CITY OF ALBUQUERQUE

February 3, 2014

**RE: Assisted Living Center
Grading and Drainage Plan
Engineers Stamp Date 1/12/14 (D16-D101)**

**CONCEPTUAL
GRADING & DRAINAGE PLAN**

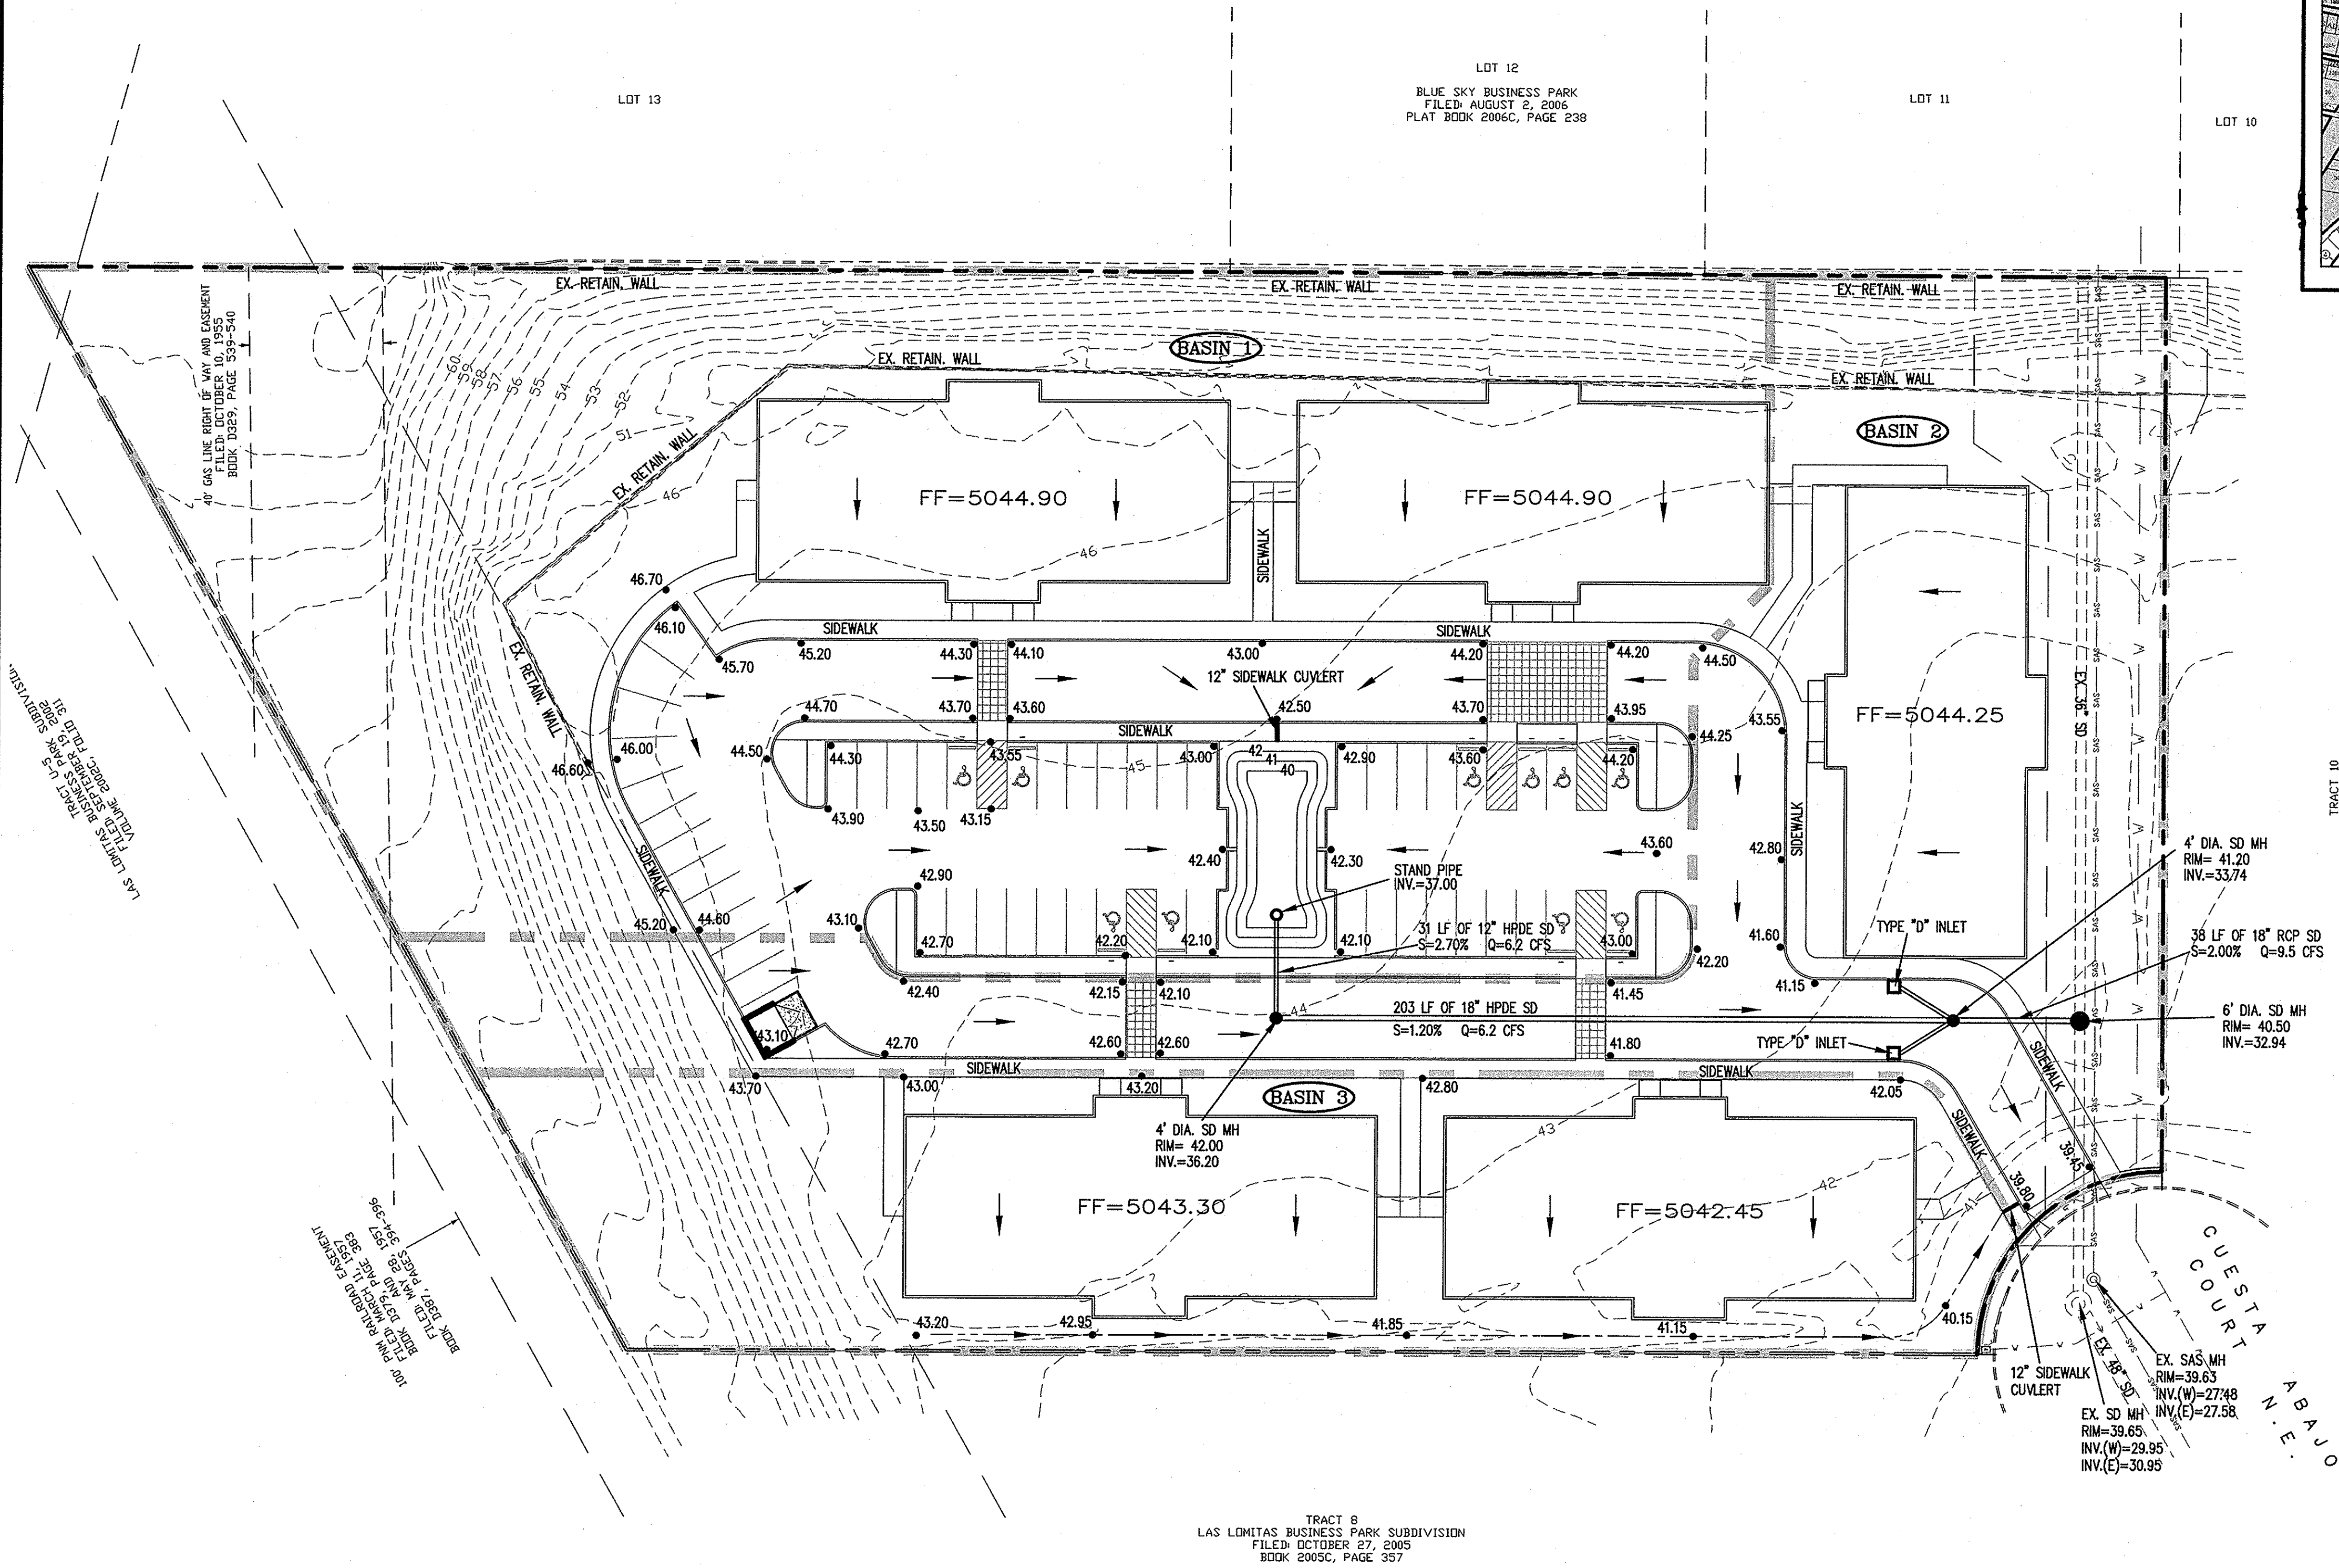
- How many phases are in this project? Are the flows for the coming phases accounted for?
- The table under the proposed conditions is not clear.
- In which direction does the roof flow?
- Are you accepting flows from the property to the west?
- Add a detail for the swale along the west property line.
- Add proposed 37, 38 and 39 contour elevations.
- Depress all landscape areas 10 feet from the building.
- An approved Erosion Sediment Control plan is required before a Building Permit can be accepted.
- Please revise the direction of the north arrow.
